# TRAILS AT ASPEN RIDGE FILING NO.2

## ROADWAY & STORM IMPROVEMENT PLANS

NOVEMBER, 2019

DESIGNED BY: NMS	SCALE	DATE ISSUED: FEBRUARY, 2020	DRAWING No. RD02
DRAWN BY: CRD	HORIZ. 1" = 40'	SHEET 5 OF 36	
CHECKED BY: NMS	VERT. 1" = 8'

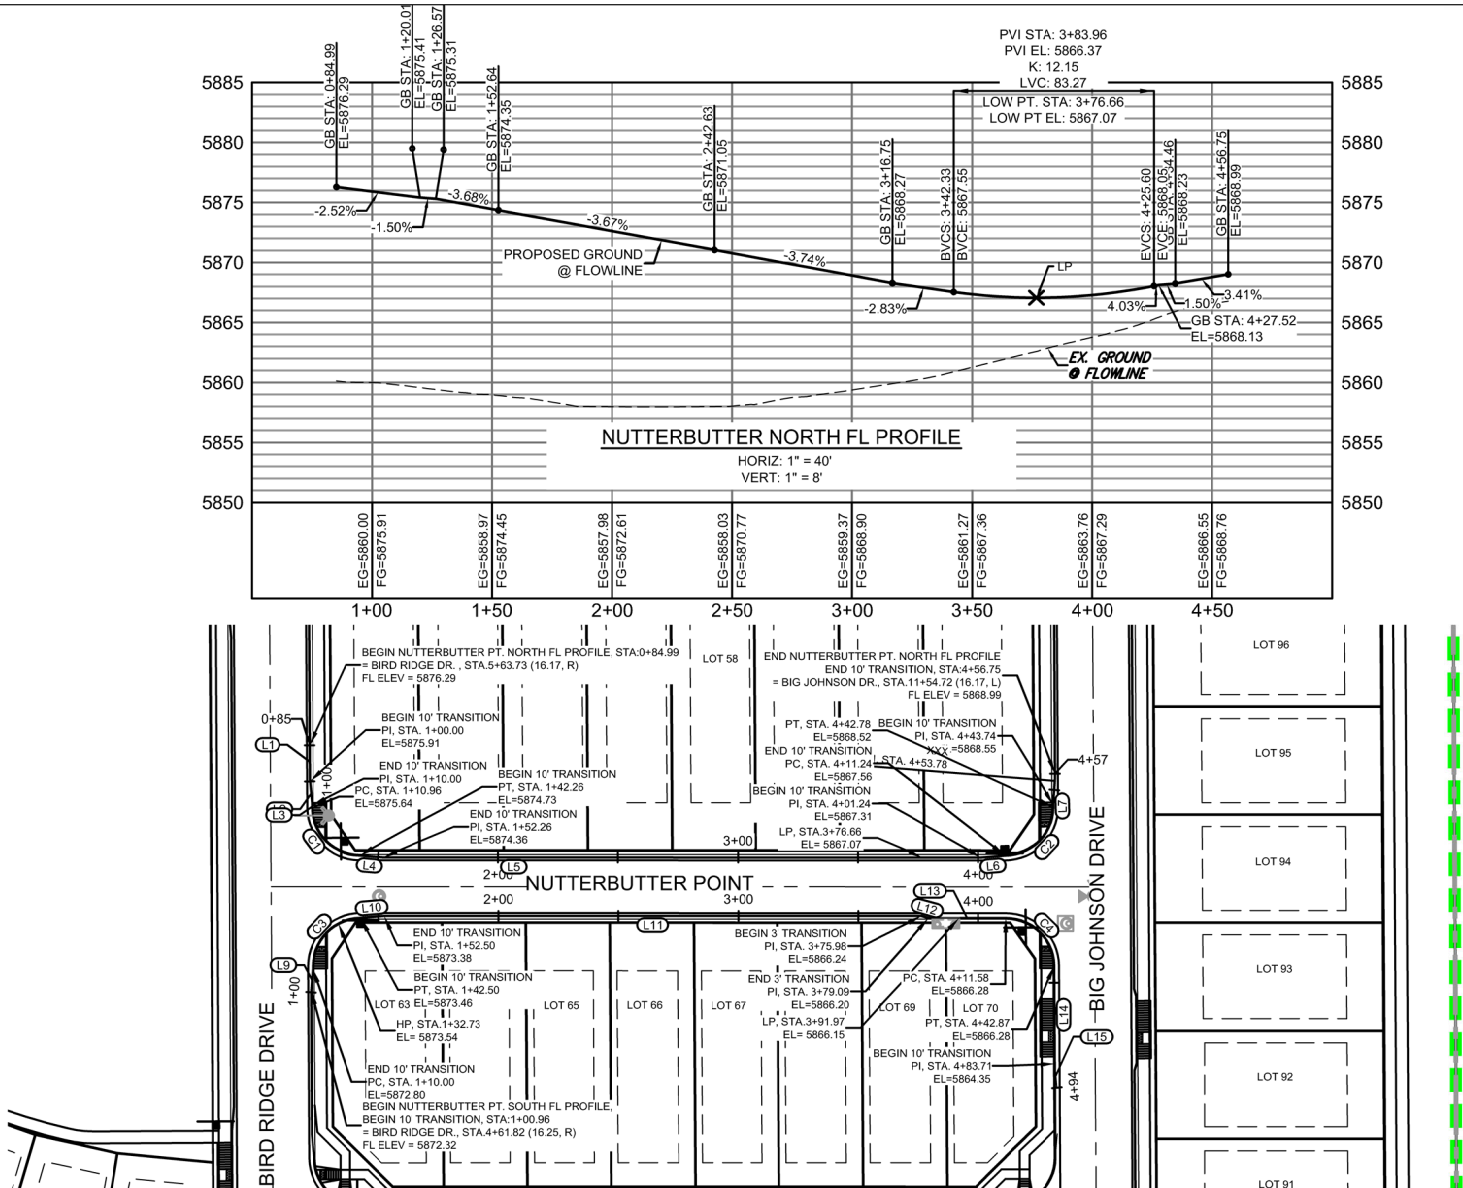
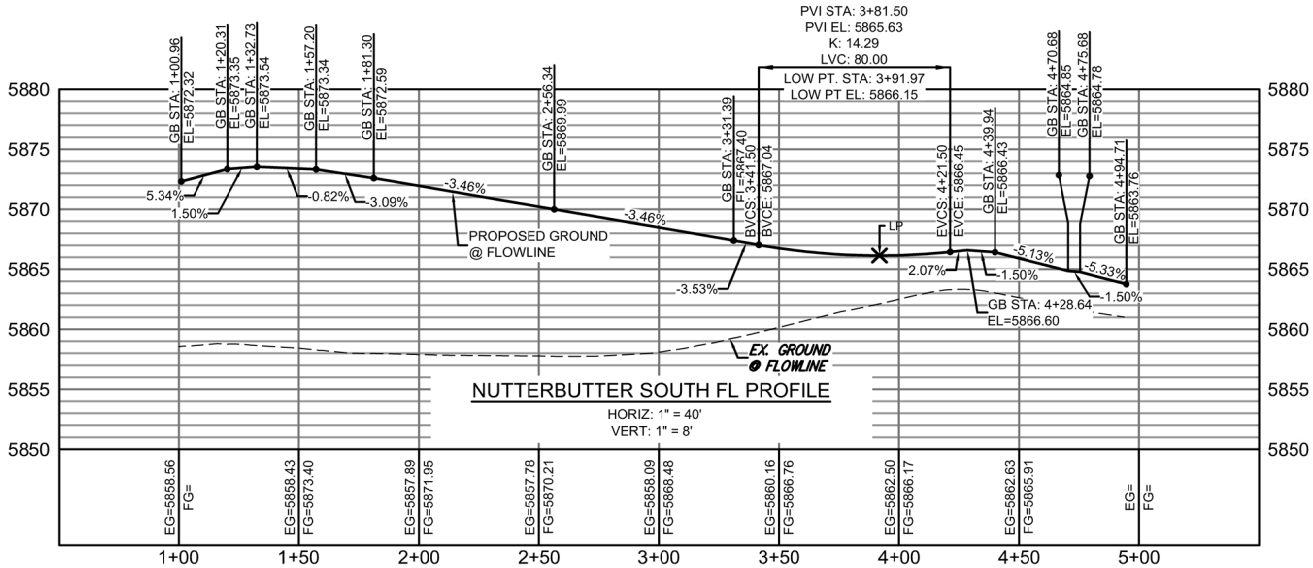
Revise or provide a deviation for k values less than the minimum.
